Rezoning Transportation Analysis

Petition Number: 2023-046

Date	Description
08-25-23	First Review (NK)
09-20-23	Second Review (NK)

SCHEMATIC SITE PLAN

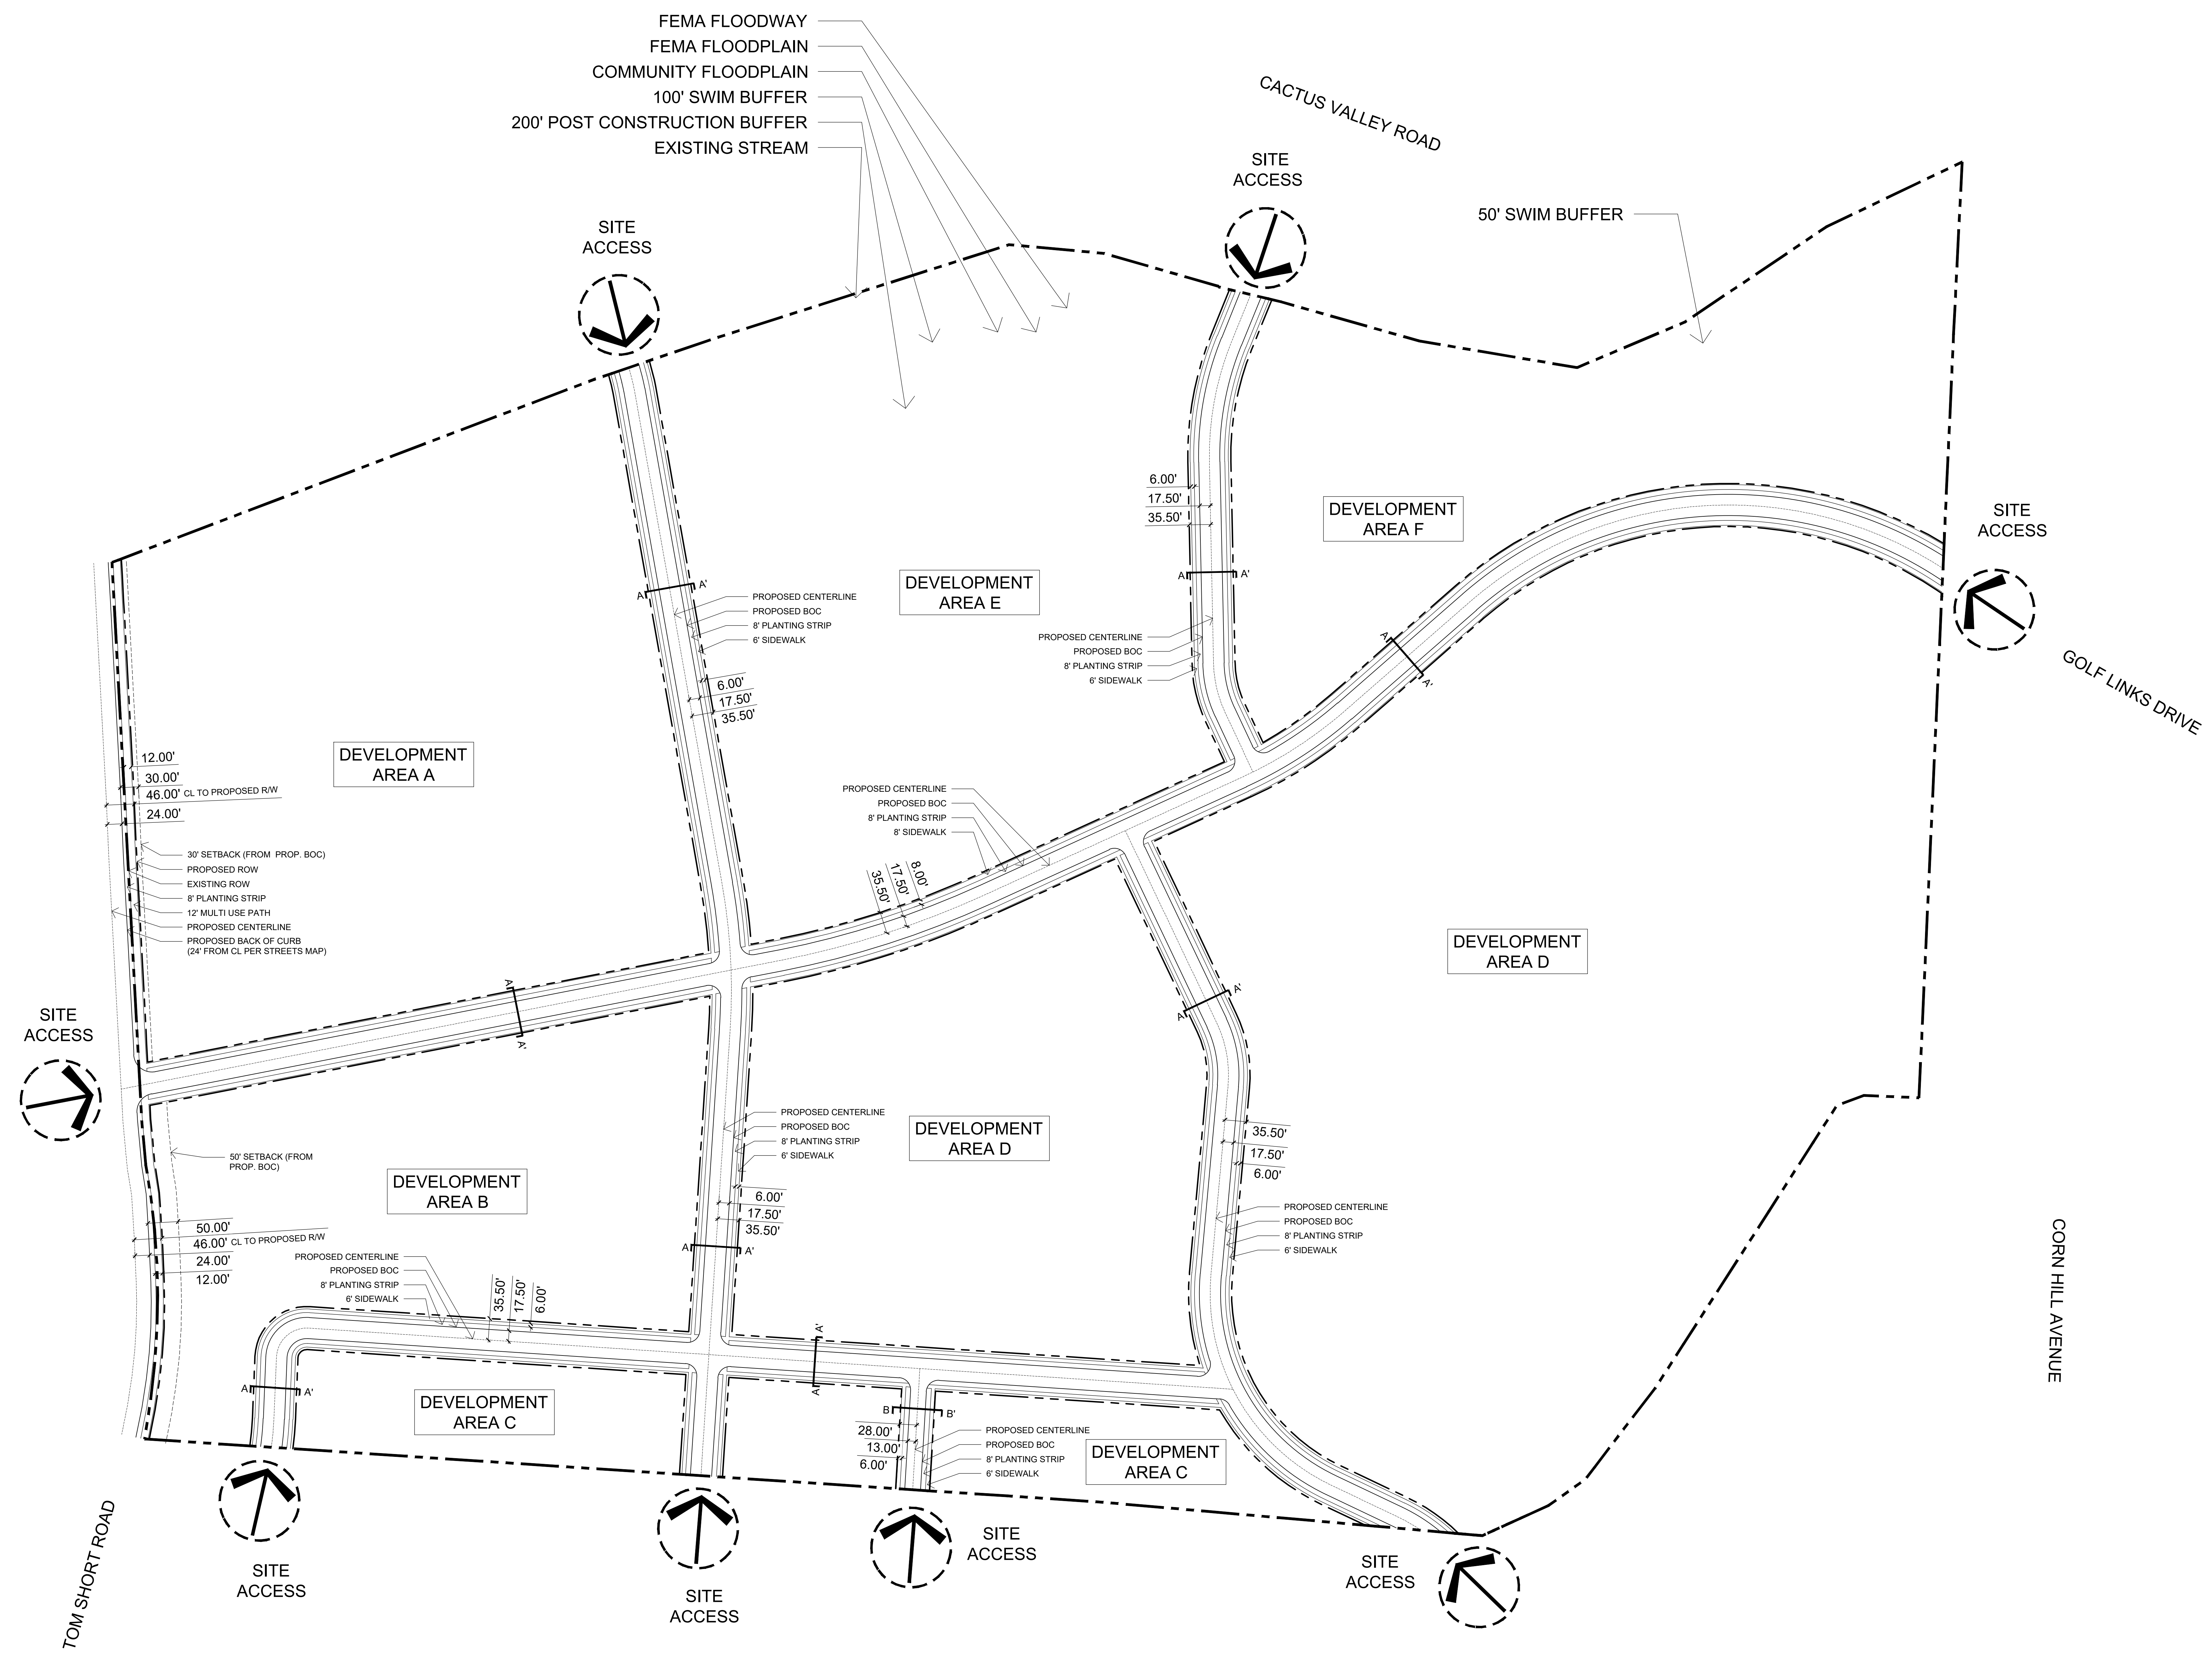
7. **Outstanding Issue 8/24/23:** Remove this intersection, and ensure all future horizontal curves meet the minimum CDOT standard of 150' radius.

8. **Outstanding Issue 8/24/23:** Align internal public roads to remove offset intersections.

9. **Outstanding Issue 8/24/23:** The horizontal curves pictured below need to have a minimum 50' separation to meet minimum CDOT standard.
